**KIRKLEES METROPOLITAN COUNCIL  
INVESTMENT & REGENERATION SERVICE**

**DELEGATED DECISION TO DETERMINE PLANNING APPLICATIONS**

Reference No:	<b>2024/62/92024/W</b>
Site Address:	14, Bankfield Terrace, Outcote Bank, Huddersfield, HD1 3HW
Description:	Erection of single storey side extension and alterations
Recommending Officer:	Molly Storer

## **OFFICER REPORT**

Proposed Side Elevation

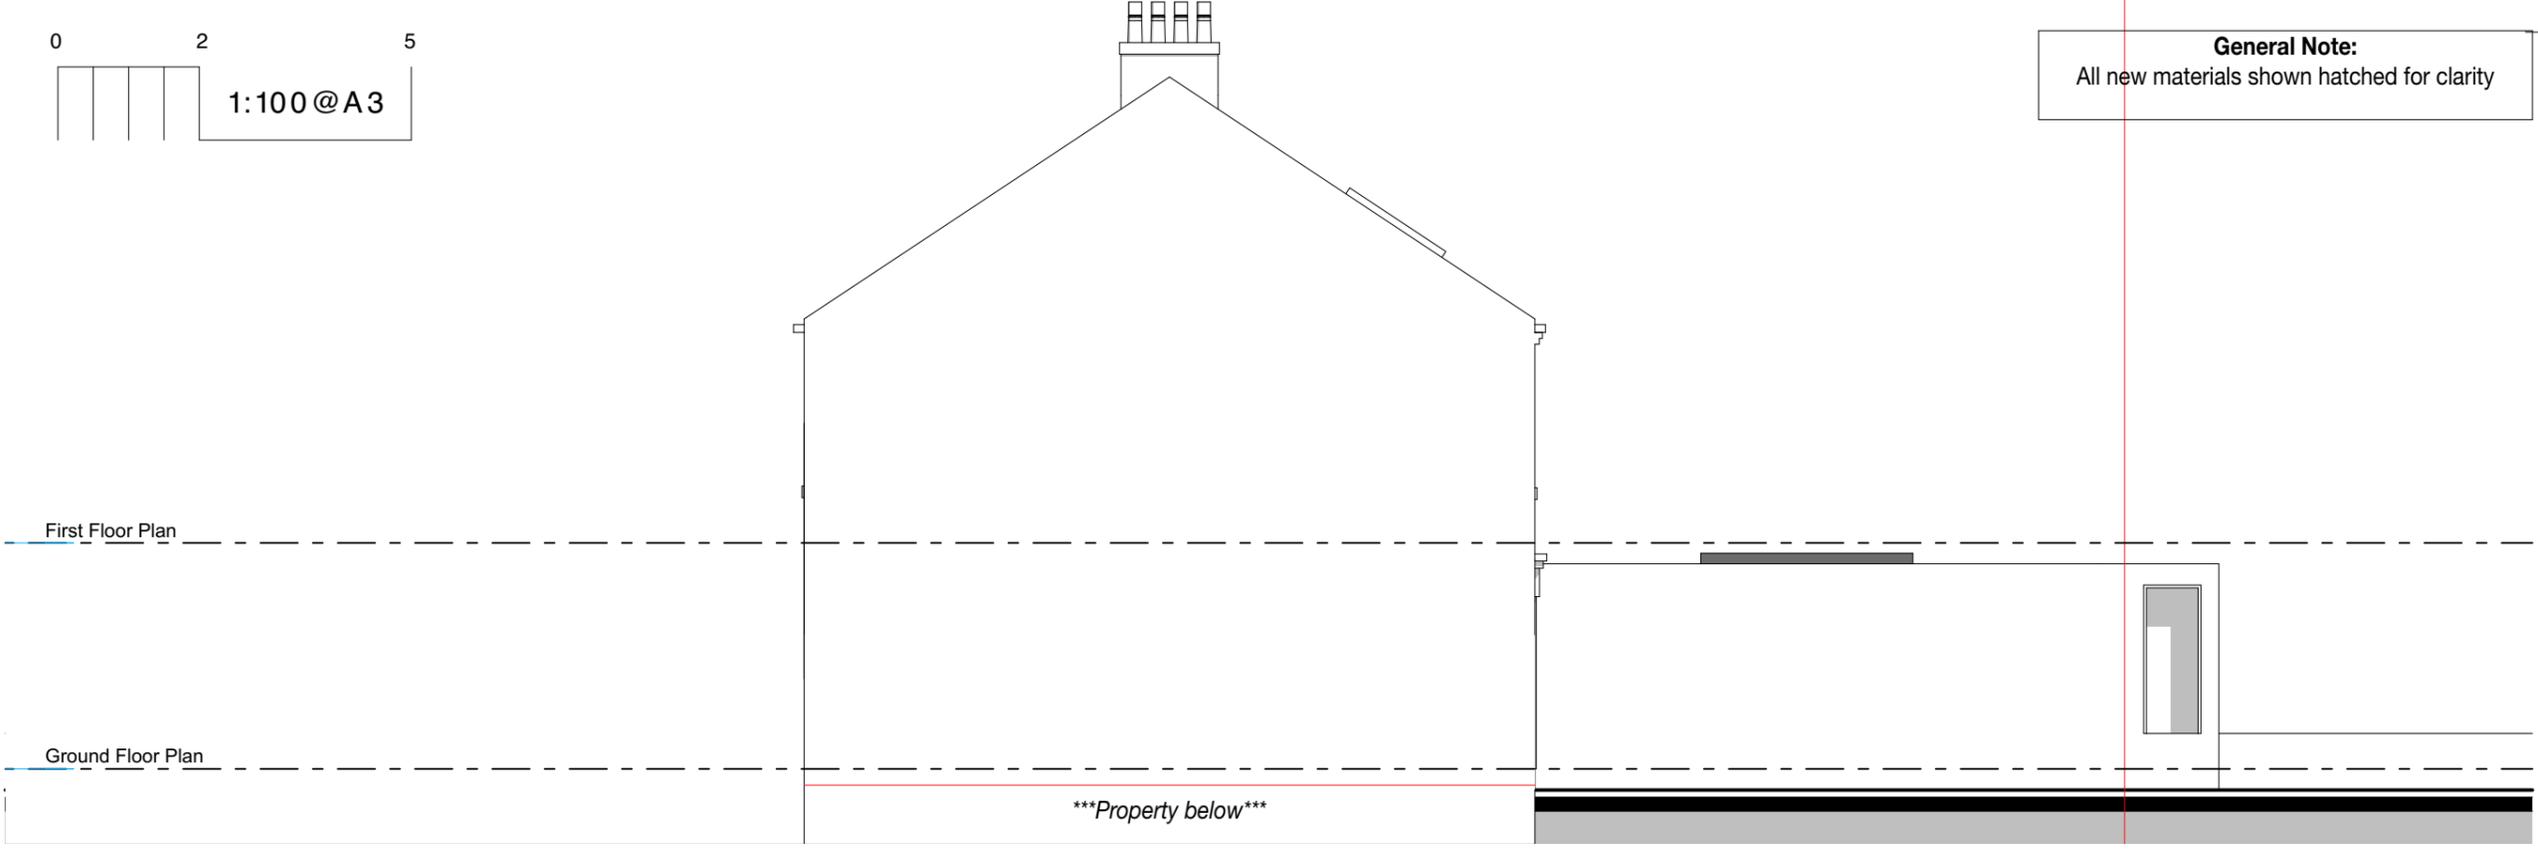
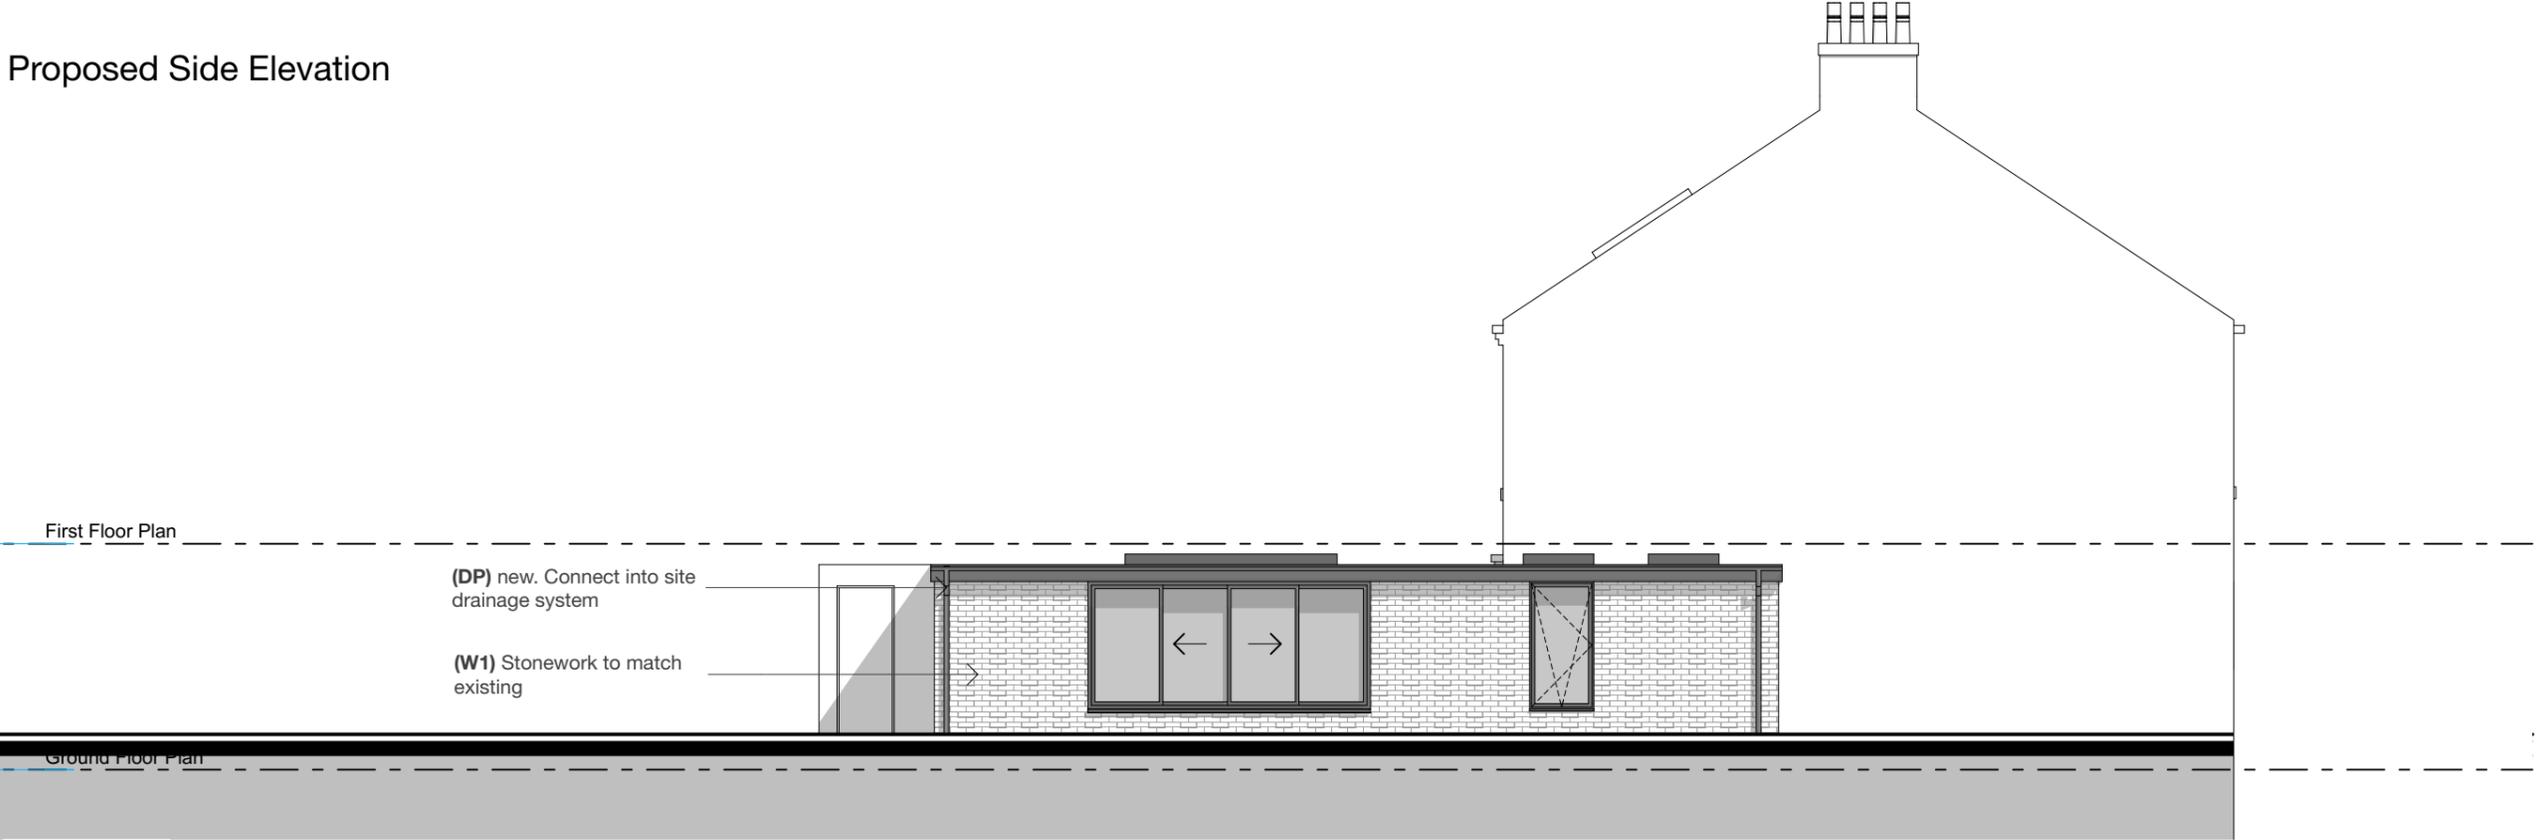
elevation of the existing property. In the new plans this element of the extension is now shown to be set behind the existing retaining wall, not overlapping the front elevation, retaining the area of amenity space directly to the front of the property and the extensive glazing to the south elevation is removed. Therefore, it is considered that the new scheme has overcome previous reasons for refusal from the 2023/92827 application, creating a design that would not be visually harmful to the host dwelling and wider area and would not appear overly dominant.

elevation facing onto this property as shown on plans within the previously refused application (ref: 2023/92827) has been removed. This elevation is now blank other than a single door towards the rear of the extension. It is considered that this openings, being an external doorway entrance, would not have a significant impact.

Plans - Proposed Ground Floor Plan

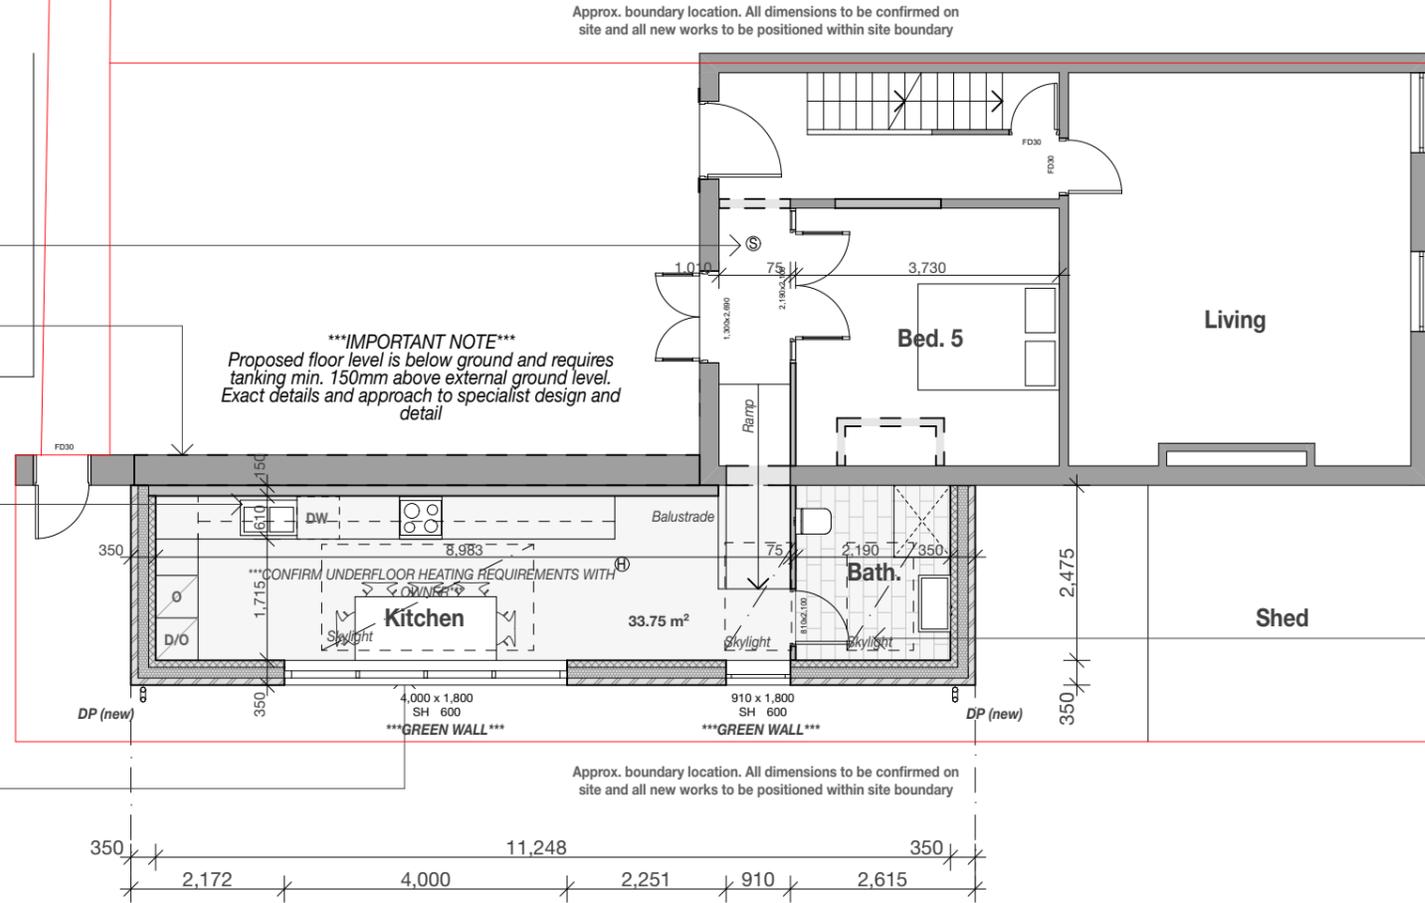
The neighbouring house to the south occupies the same building line and same ground level as the host property. These properties occupy a relatively small area of land and are located in close proximity to one another. Due to the side extension now being set back behind the retaining wall the outlook from No.16 will remain unchanged as the extension will be screened by this wall meaning the extension will not have an unduly overbearing, oppressive impact. Furthermore, the significant amount of glazing within the southern
